**From:** Brenda Larsen  
**Sent:** Friday, November 01, 2013 12:13 PM  
**To:** Jeff Watson  
**Subject:** RE: BL-13-00024 Taylor

Re: Taylor (BL-13-00024)

RECORD-OF-SURVEY FOR BOUNDARY LINE ADJUSTMENT OF
 LOTS 1 & 2 OF THE TAYLOR SHORT PLAT #06-90 AS
 PREVIOUSLY RECORDED IN BOOK I OF SHORT PLATS, PG 222;
 AFN 200708170059.

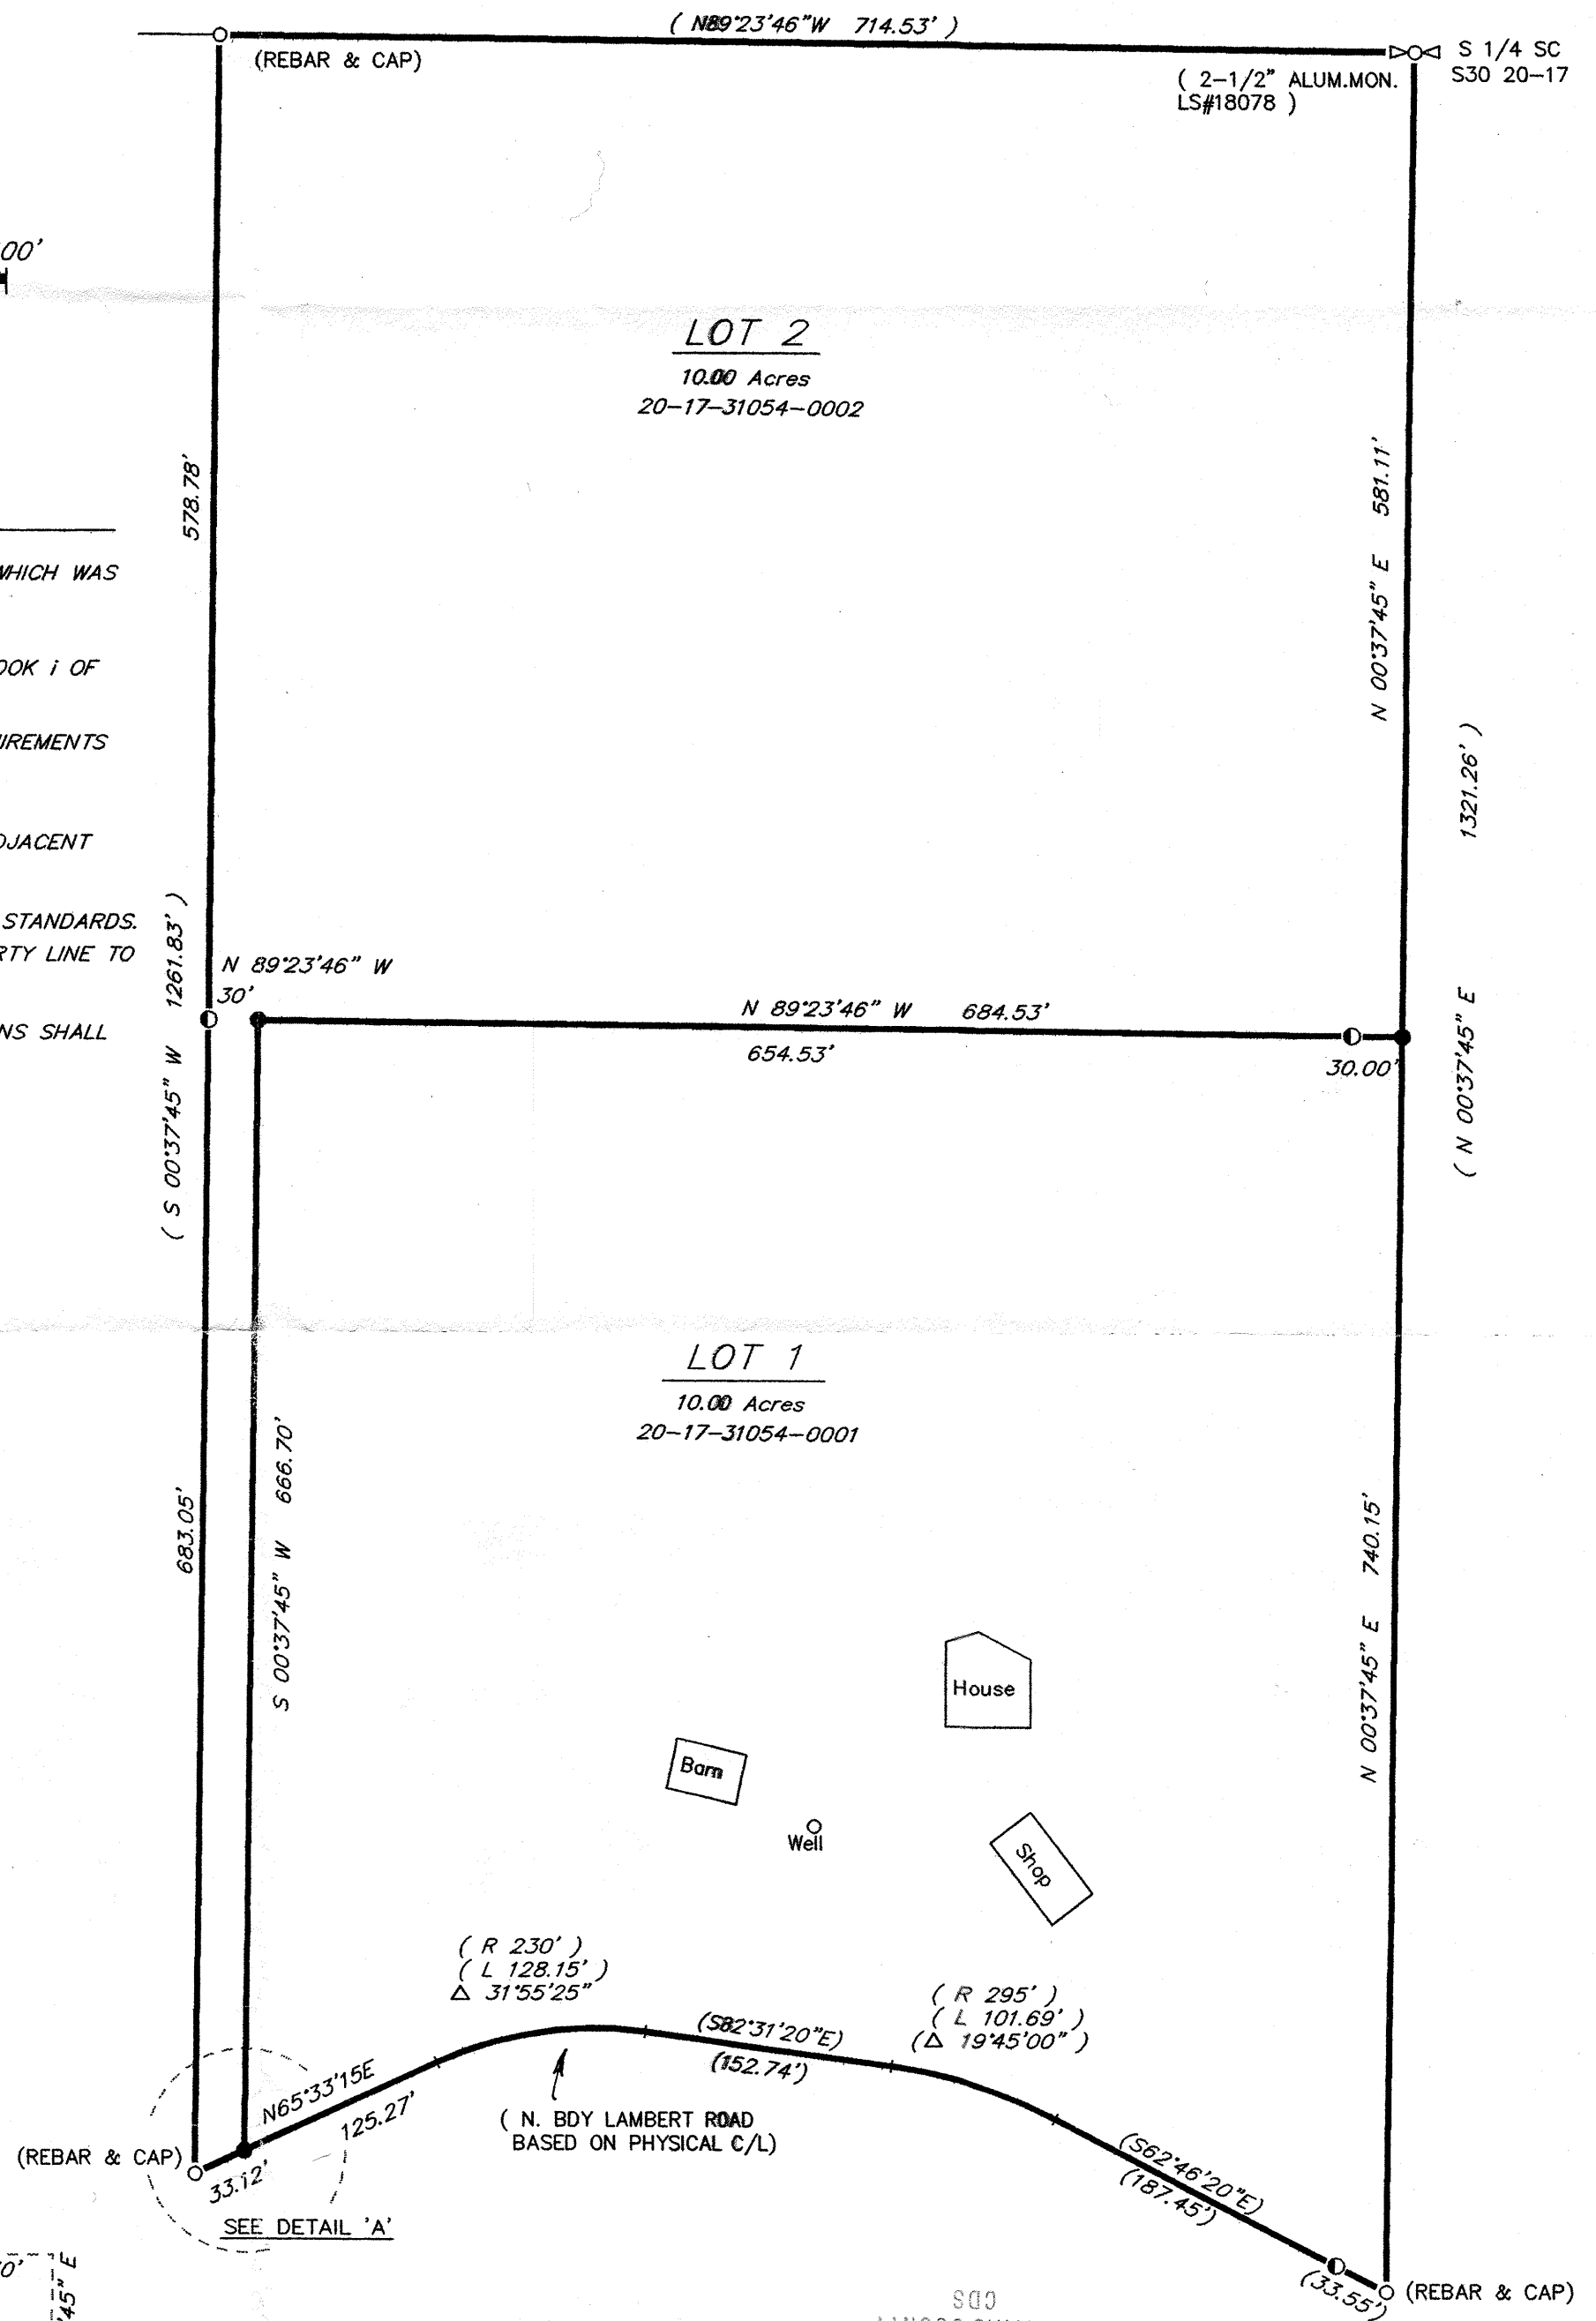
- Ensure that boundary line adjustments do not infringe upon existing structures, to include propane tanks, etc.
- Ensure adequate access for fire apparatus. Any driveways or access points created based off the new lot configurations shall comply with Kittitas County Code 20.02.030.
- All future development must comply with the International Fire Code.
